MONUMENT FIRE DISTRICT

To: Development Review, El Paso County
From: Jonathan Bradley, Fire Marshal
Subject: Monument Glamping I, AL Special Use
Date: April 11, 2024

The Monument Fire District has reviewed the plan for Monument Glamping I. Based on our initial review of site access, water supply, and fire mitigation, we have the following comments.

SITE PLAN

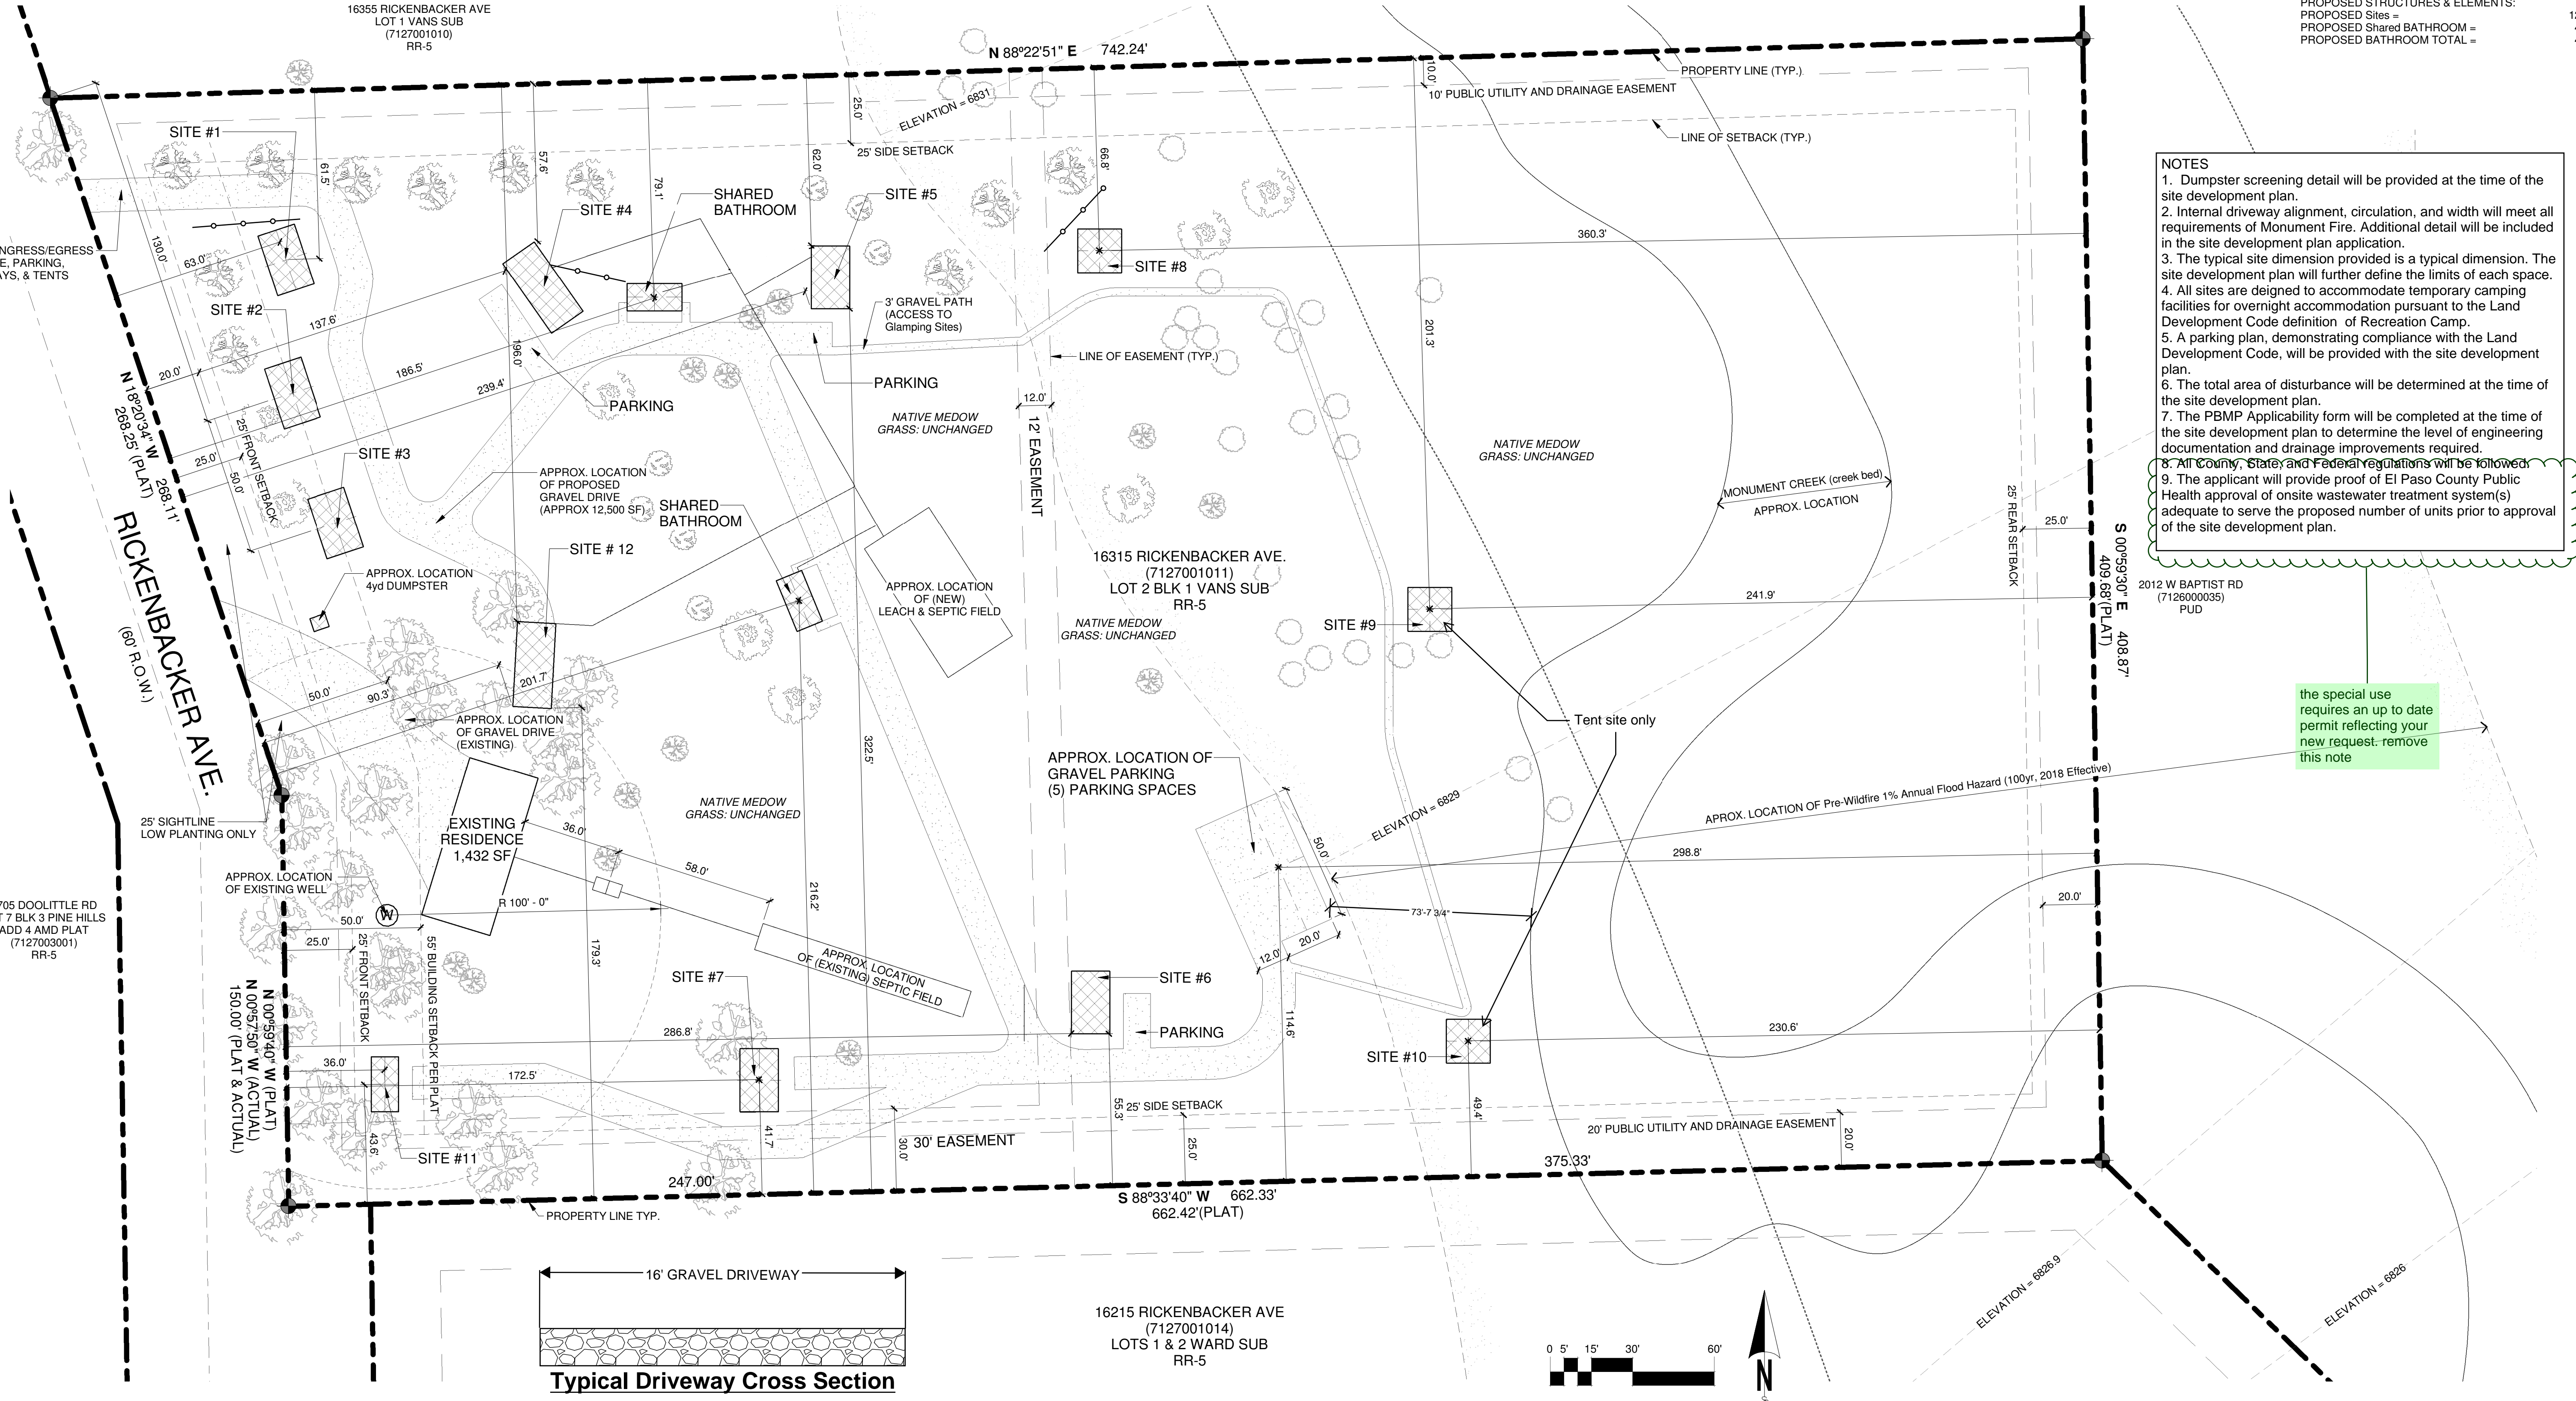
- The fire department concurs with the road width recommendations per LDC 6.3 noted in the site plan responses document uploaded on 4/8/24. There are sufficient turnaround areas in the current site plan to meet fire department requirements.
- There are no mentions of water supply for firefighting efforts. We want to acknowledge that the water supply will require water tenders to shuttle water in the event of a fire.
- There is limited vegetation on this site and the fire department is comfortable with the current state of wildfire mitigation on the property.
